The British Horse Society

Planning Inspectorate

21 Nov. 24

Oaklands Solar Farm proposal

3200-3299/3299 Oaklands Solar Farm/Project Files/CAD			
	A	MJ	16.08.23

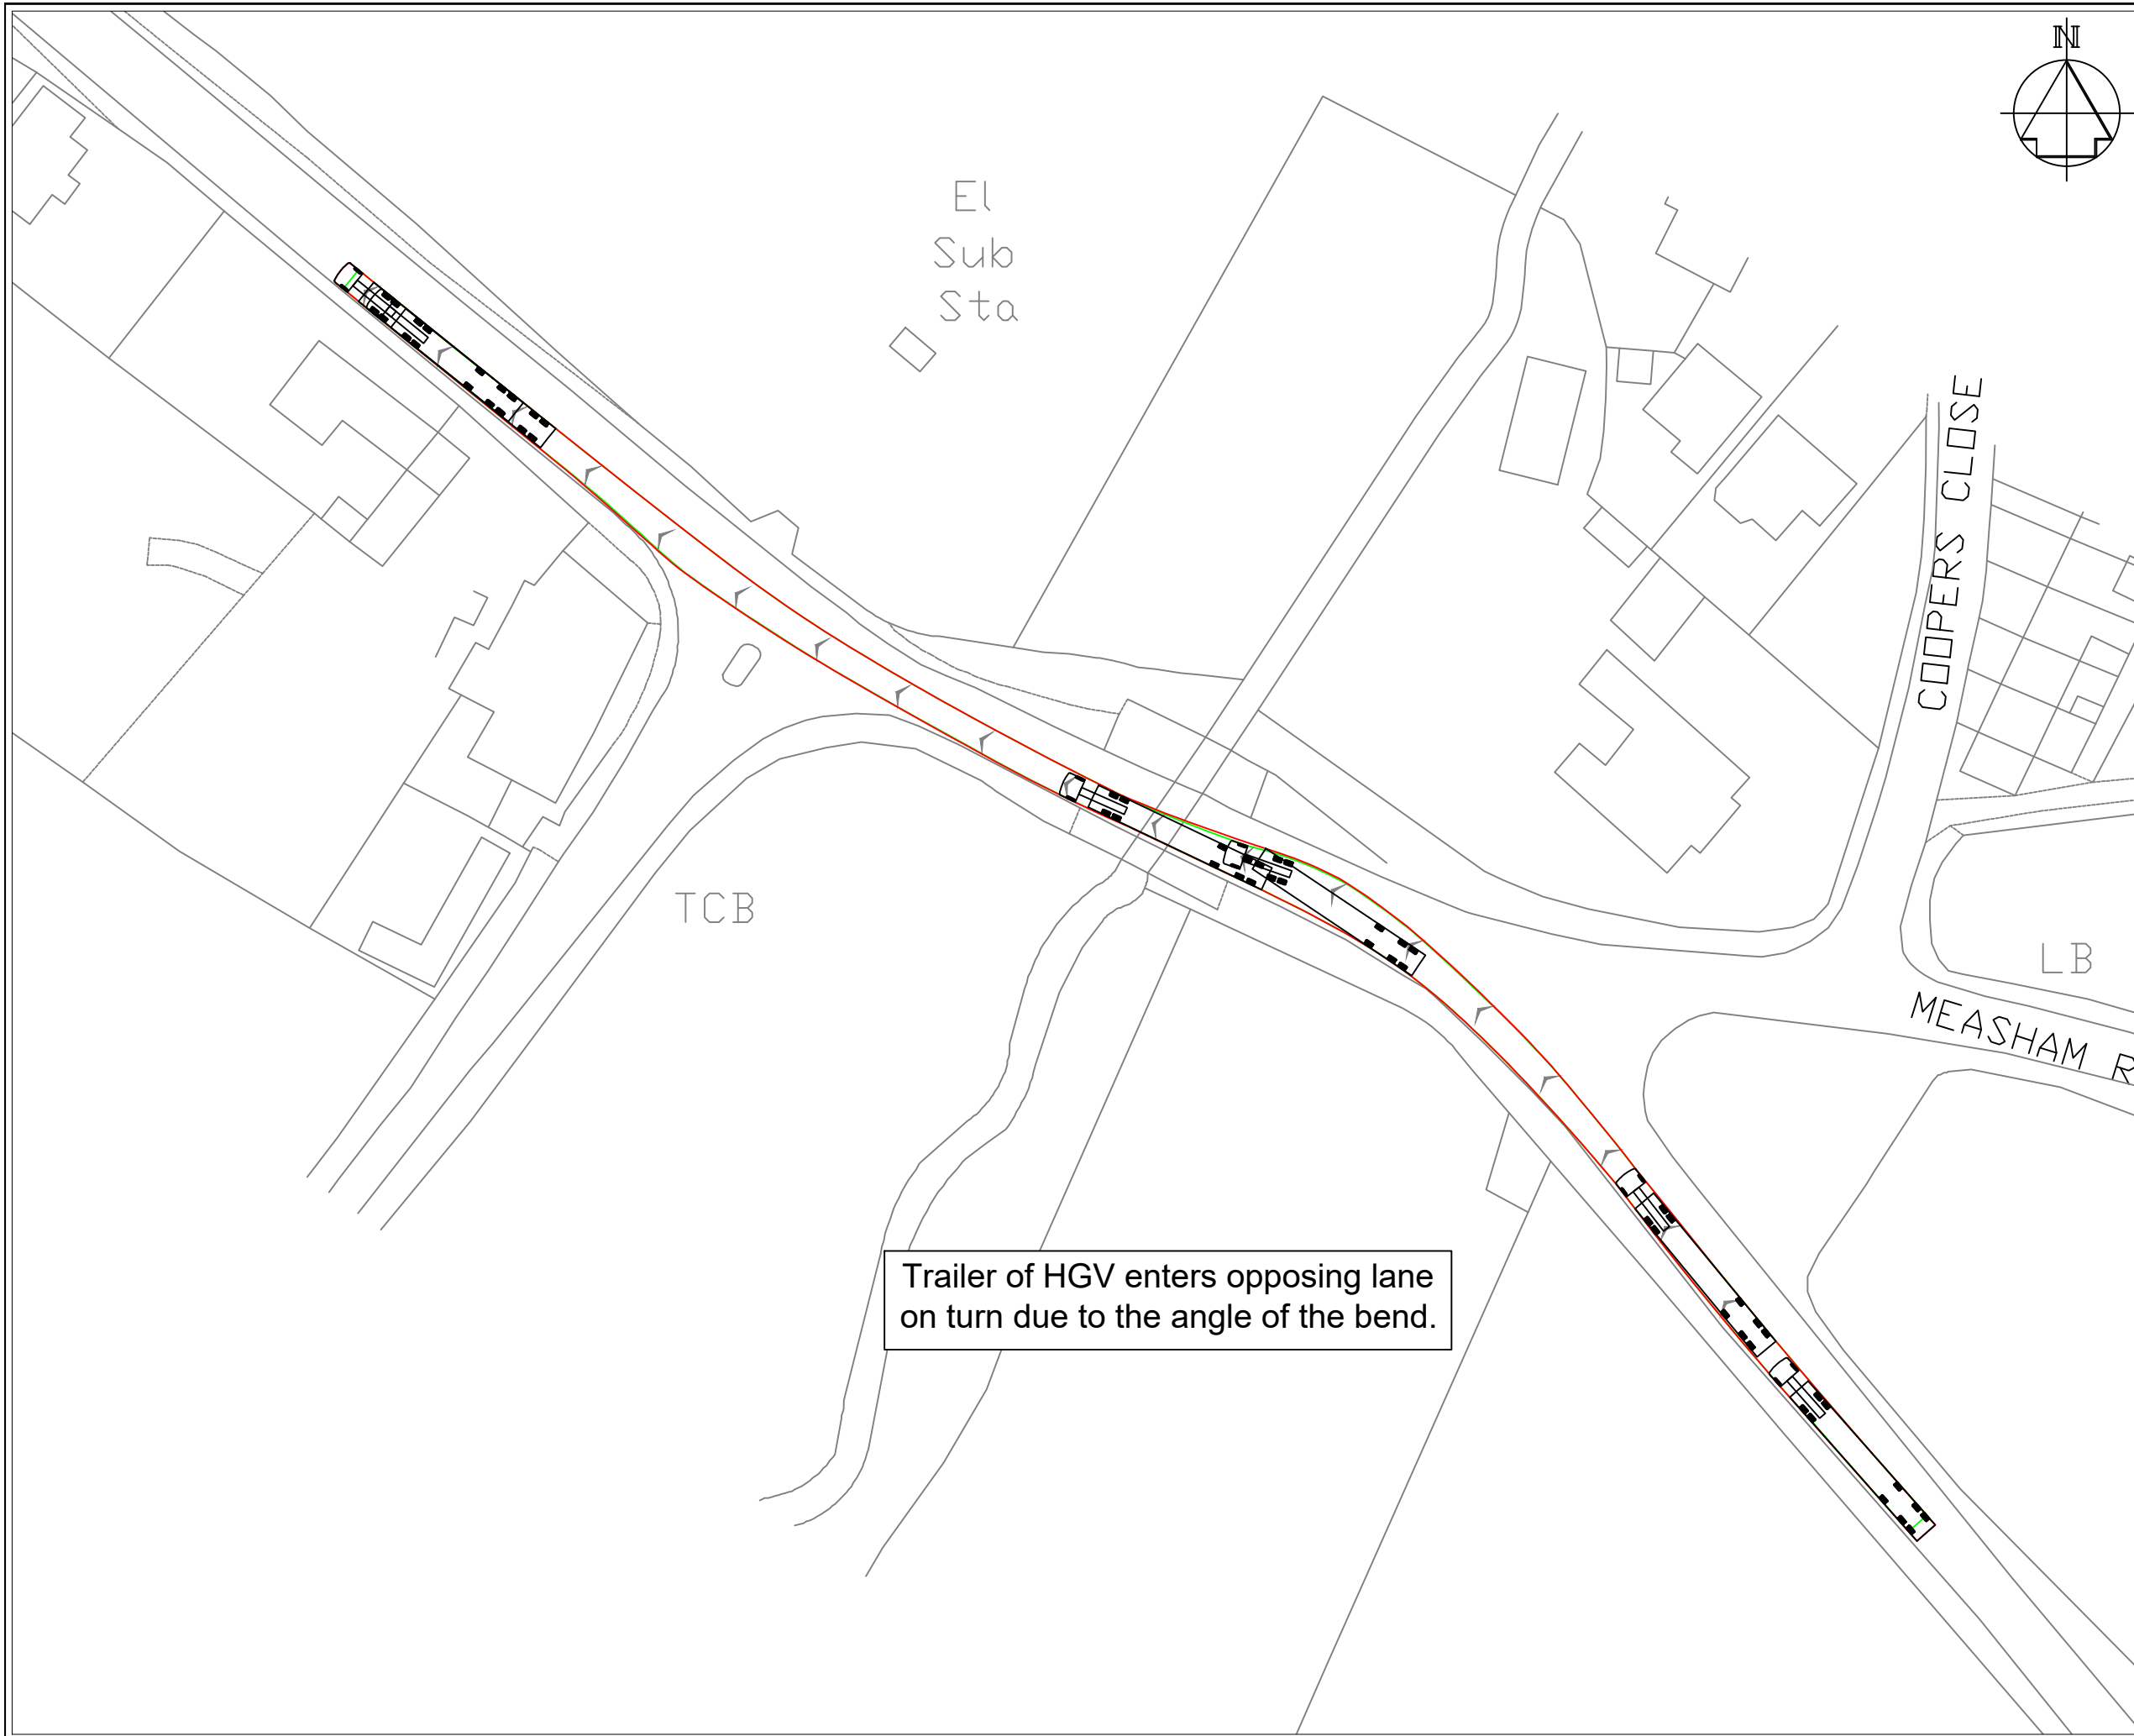
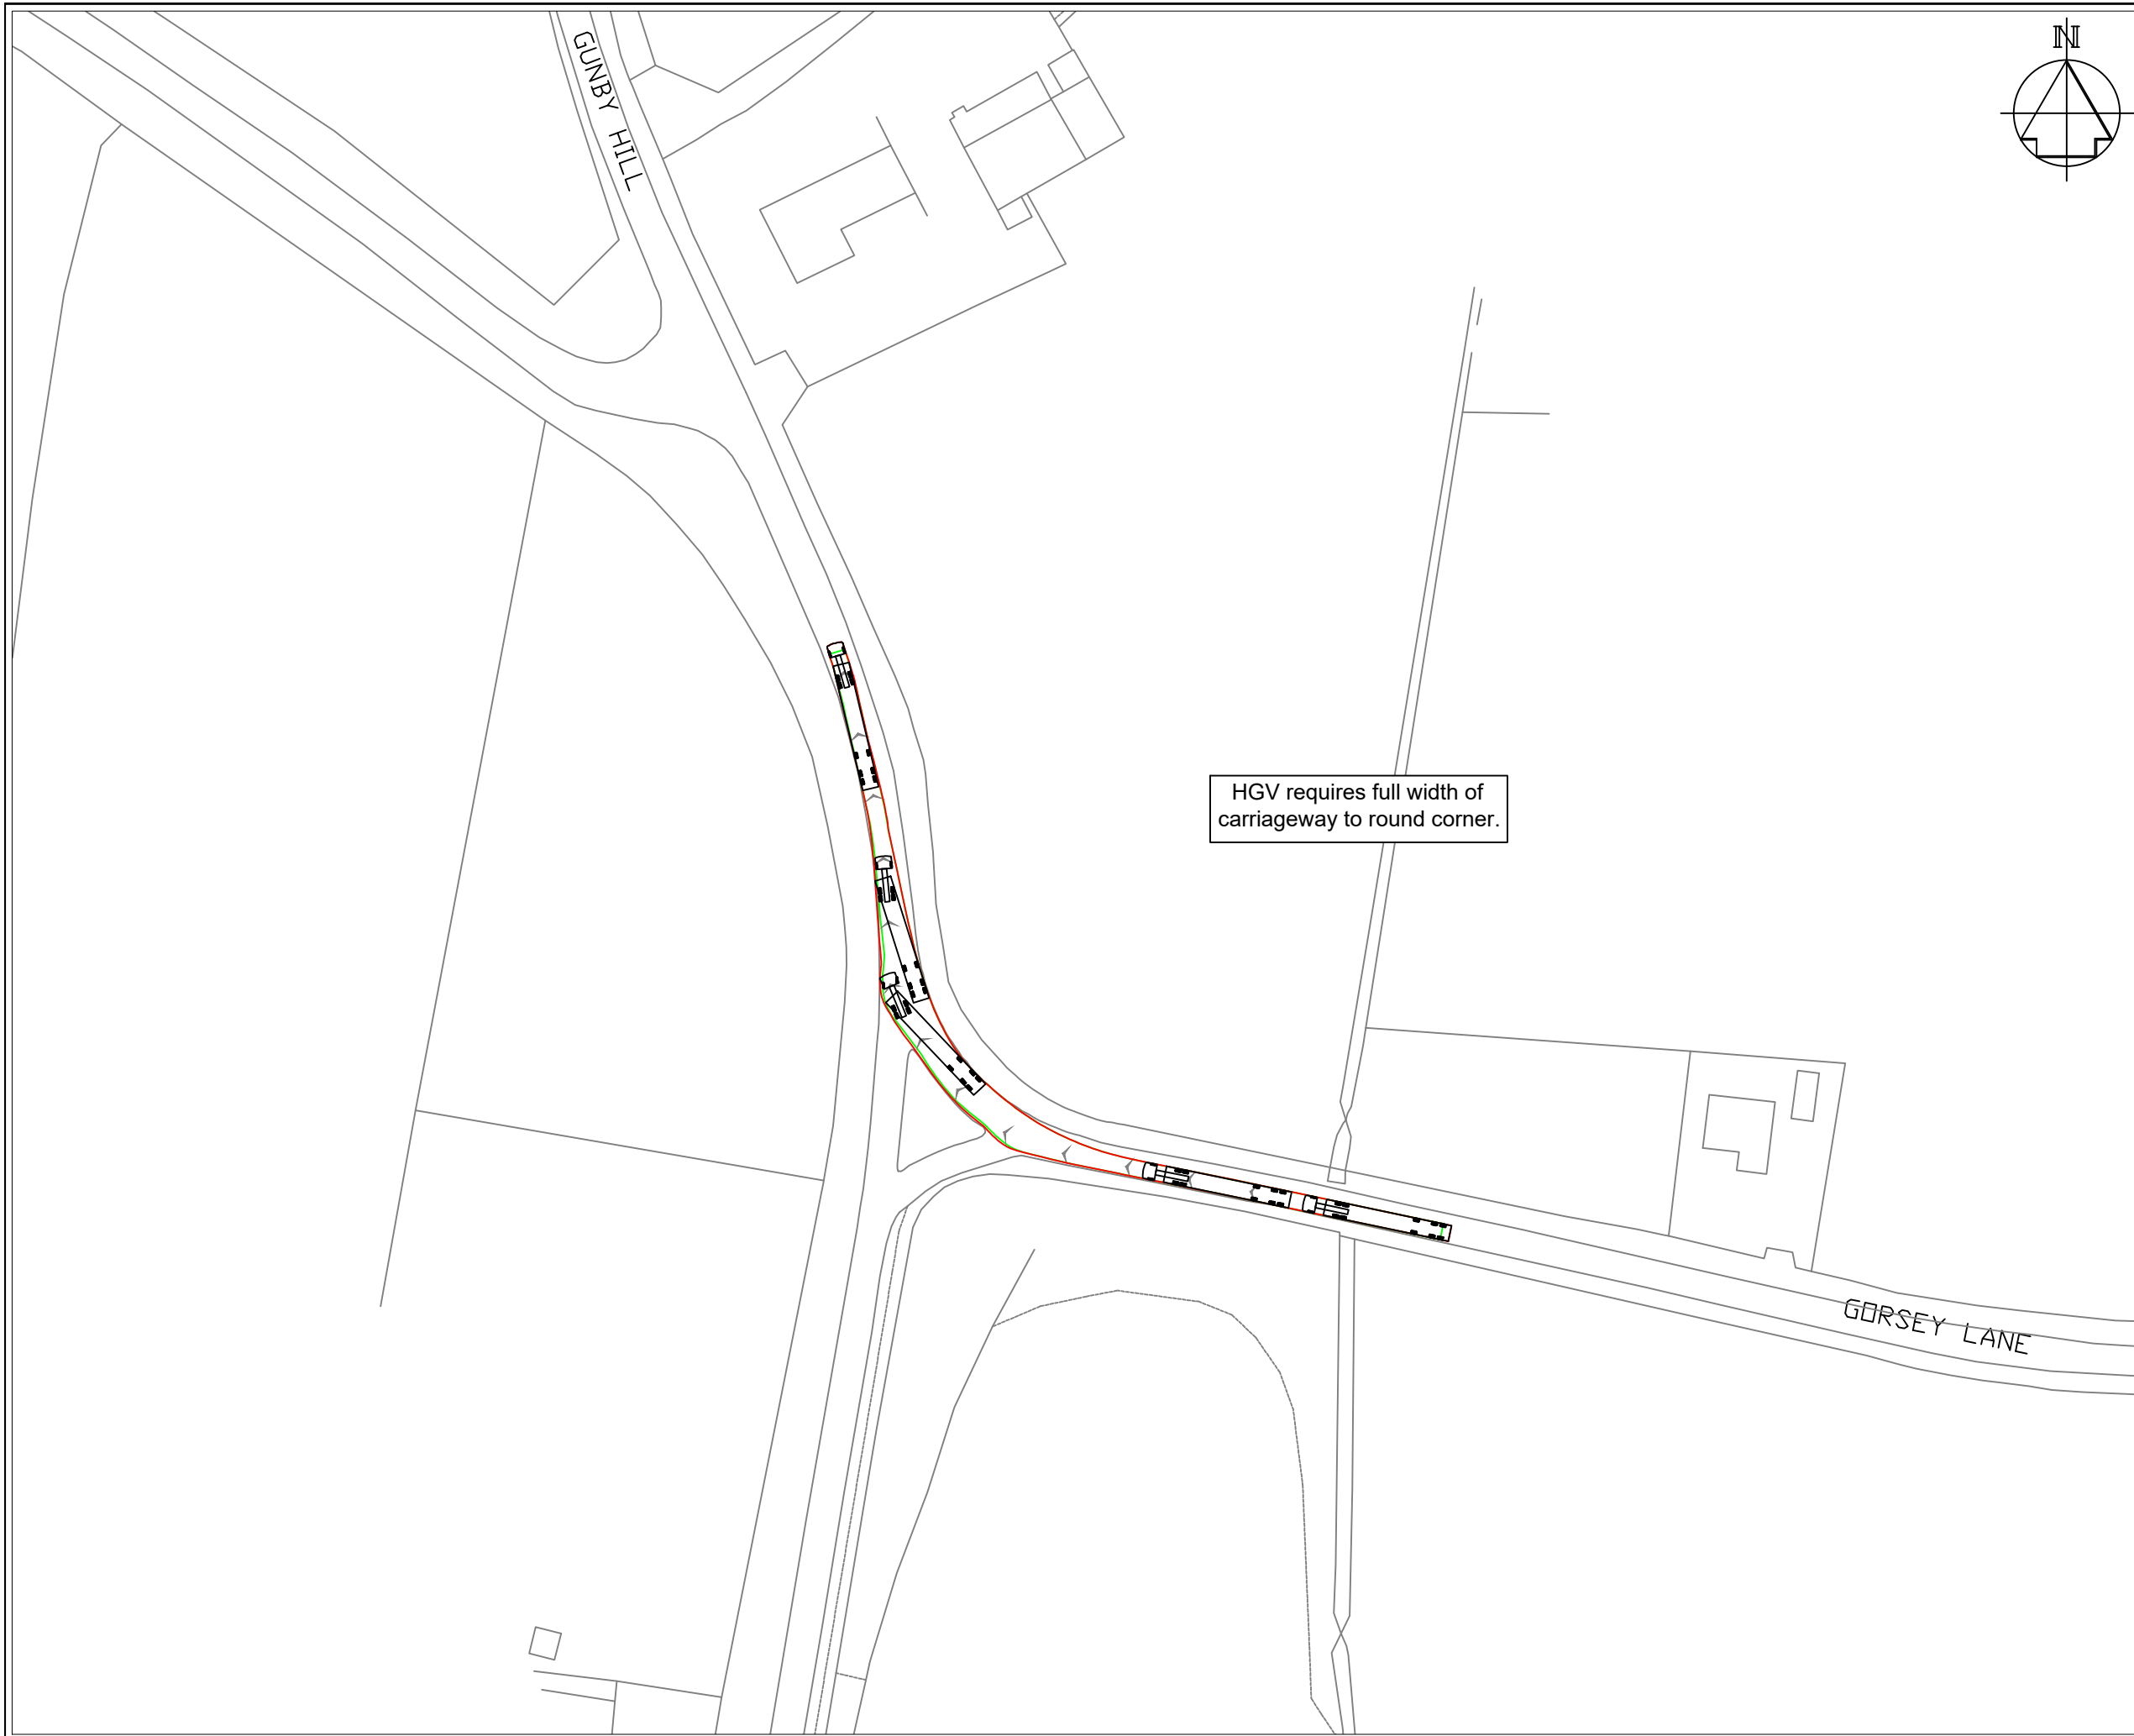
- An abnormal load is mentioned. Local riders are concerned that the abnormal load route would pass both Grangewood livery and Sealbrook livery yards. How will this be managed for safety?
